RE: Planning Application : BR/48/20/HH for a two storey rear chalet extension at 12 Cavendish Road, Bognor Regis.

sheet 2 of 3

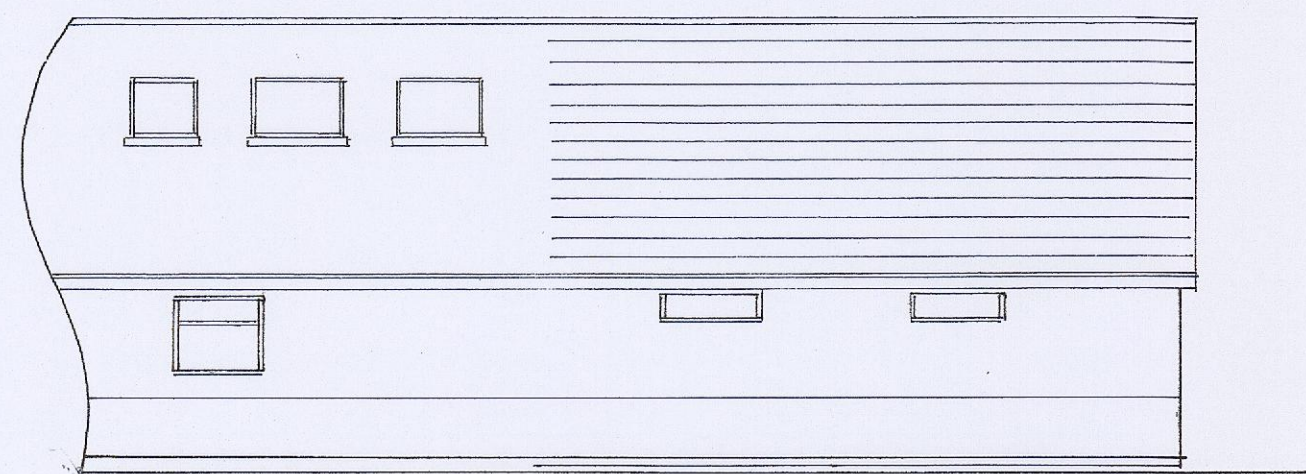
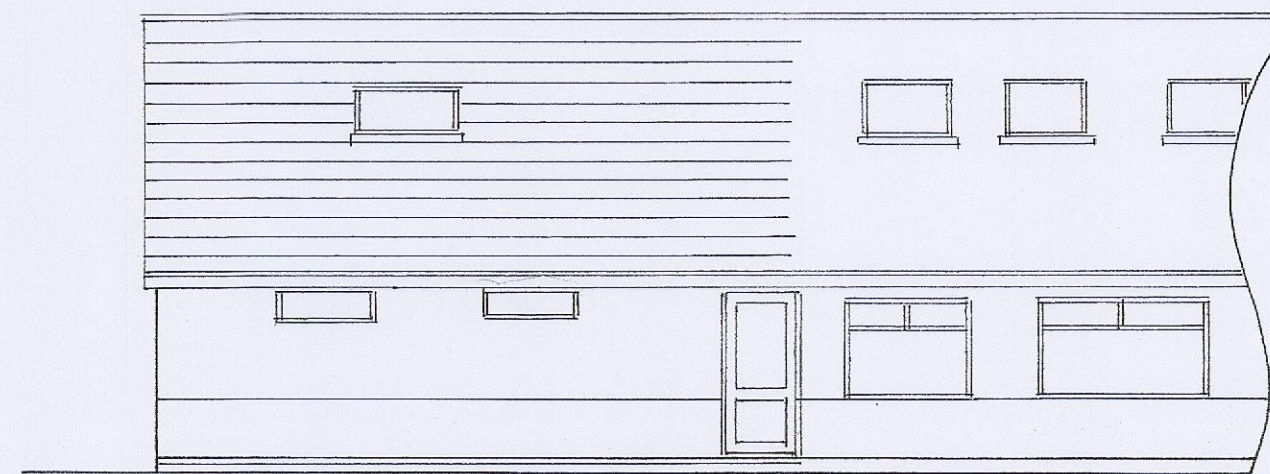
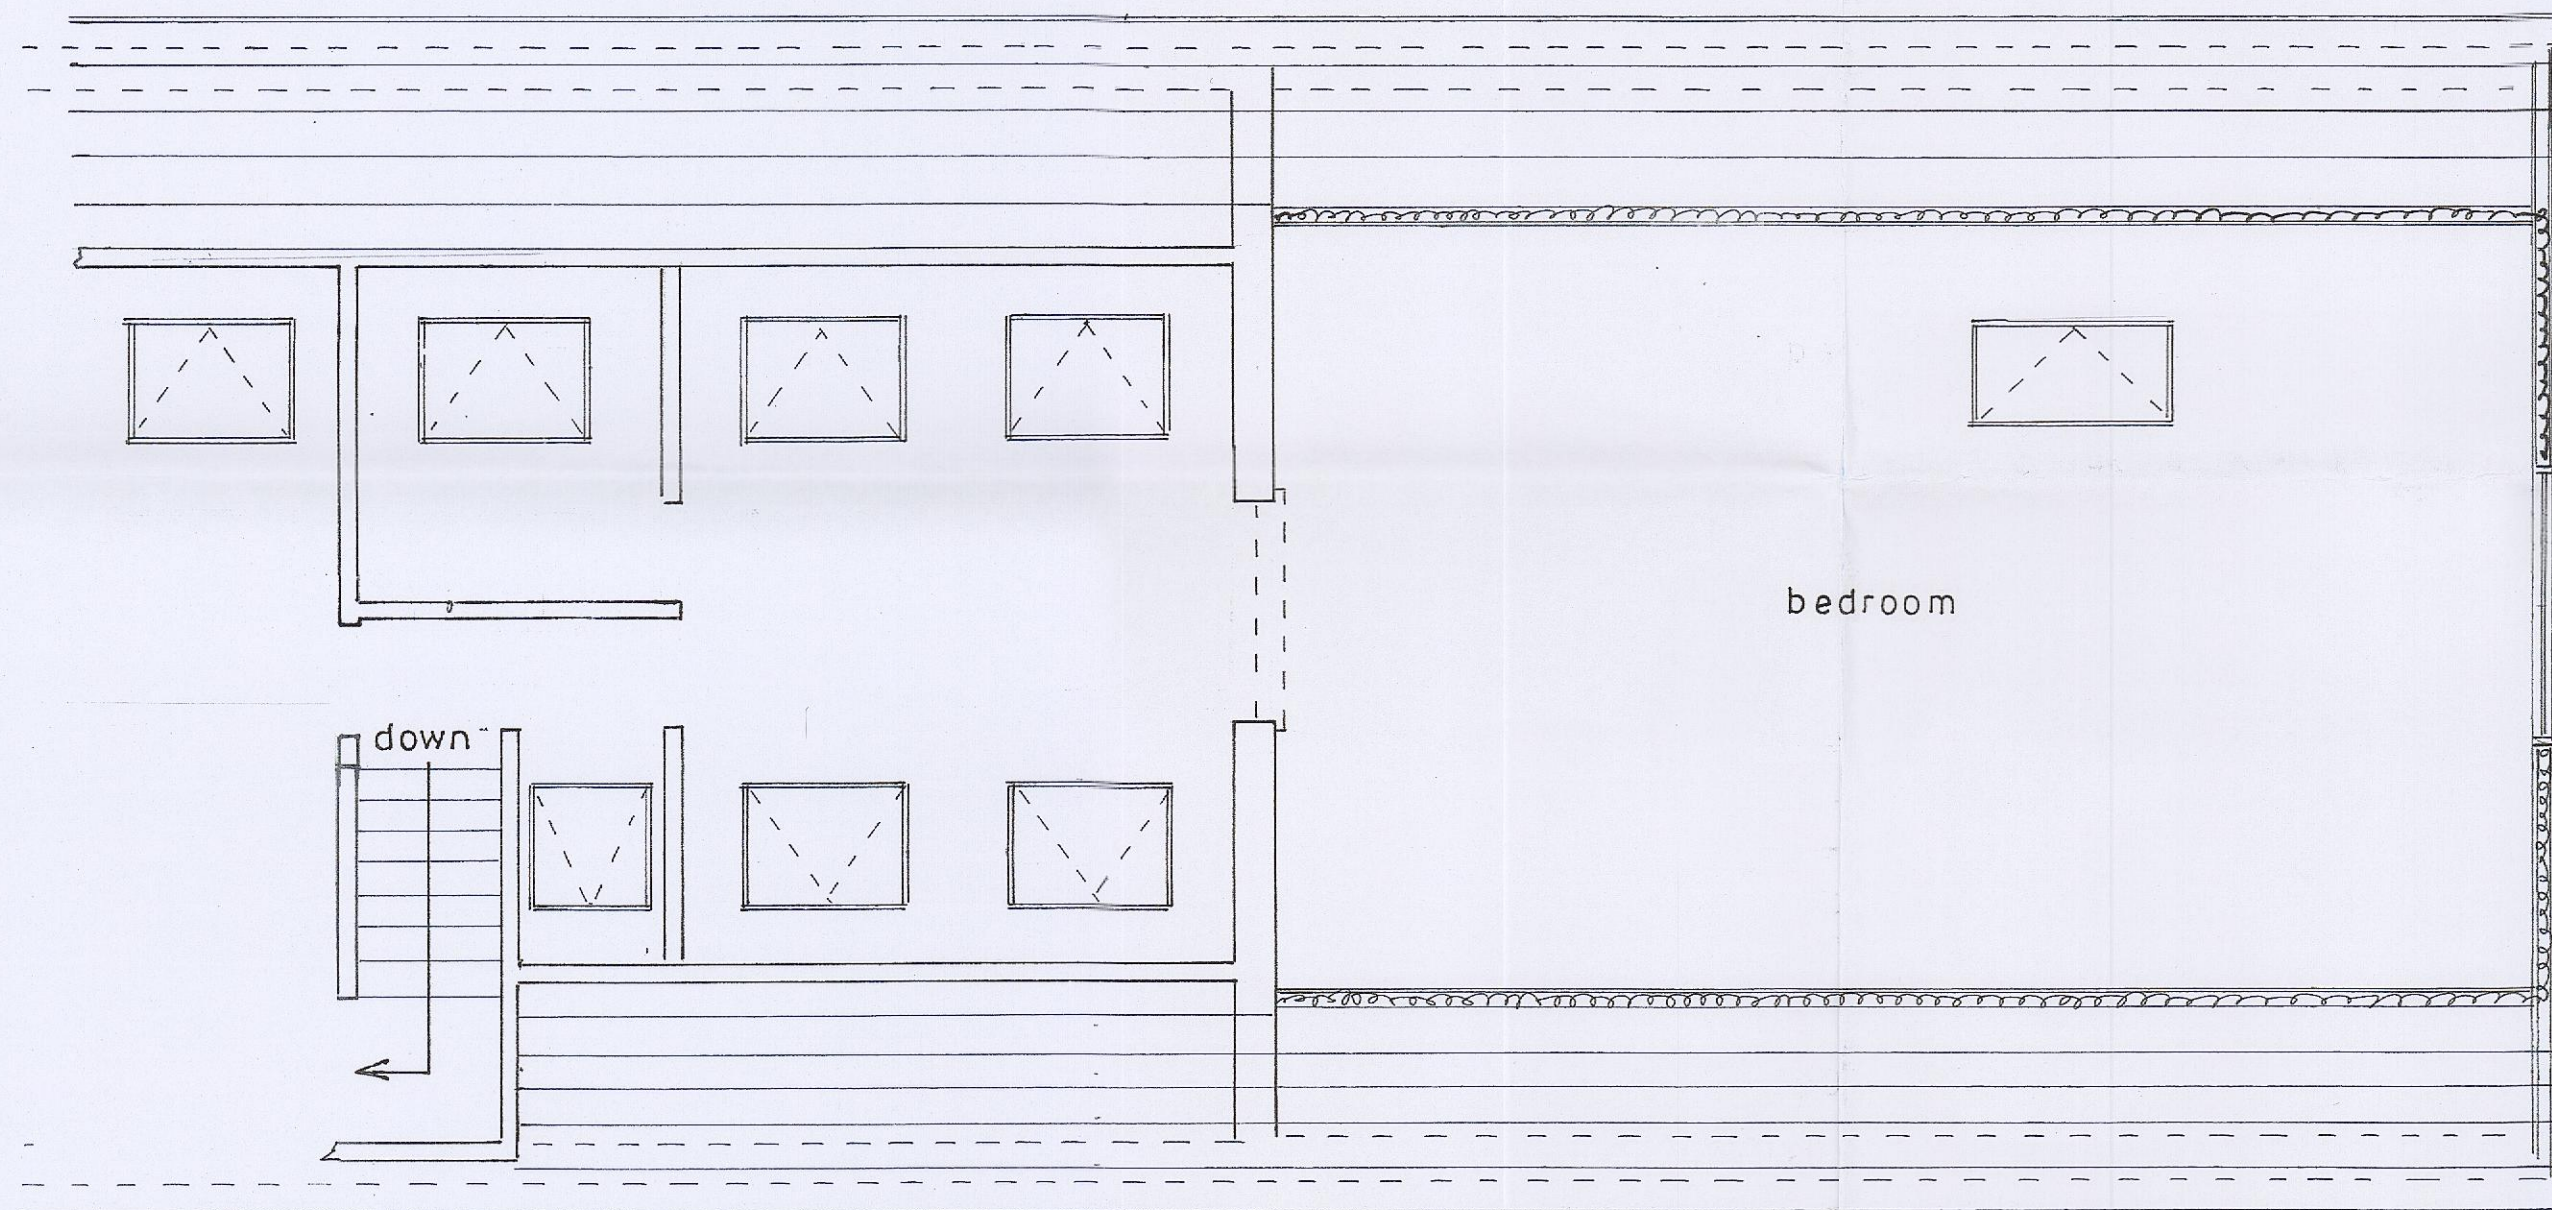
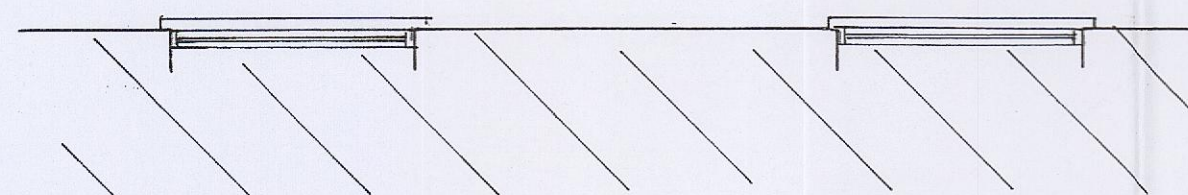
Specifically, the development will overlook much of my garden and that of my neighbours, leading to a marked loss of privacy.

This would have a noticeable impact on our residential amenity, by way of overlooking, overshadowing and loss of privacy. Moreover I believe the proposed development is also out-of-scale compared to existing developments in this vicinity, with the additional proposed area being over 75% of the current area of the dwelling.
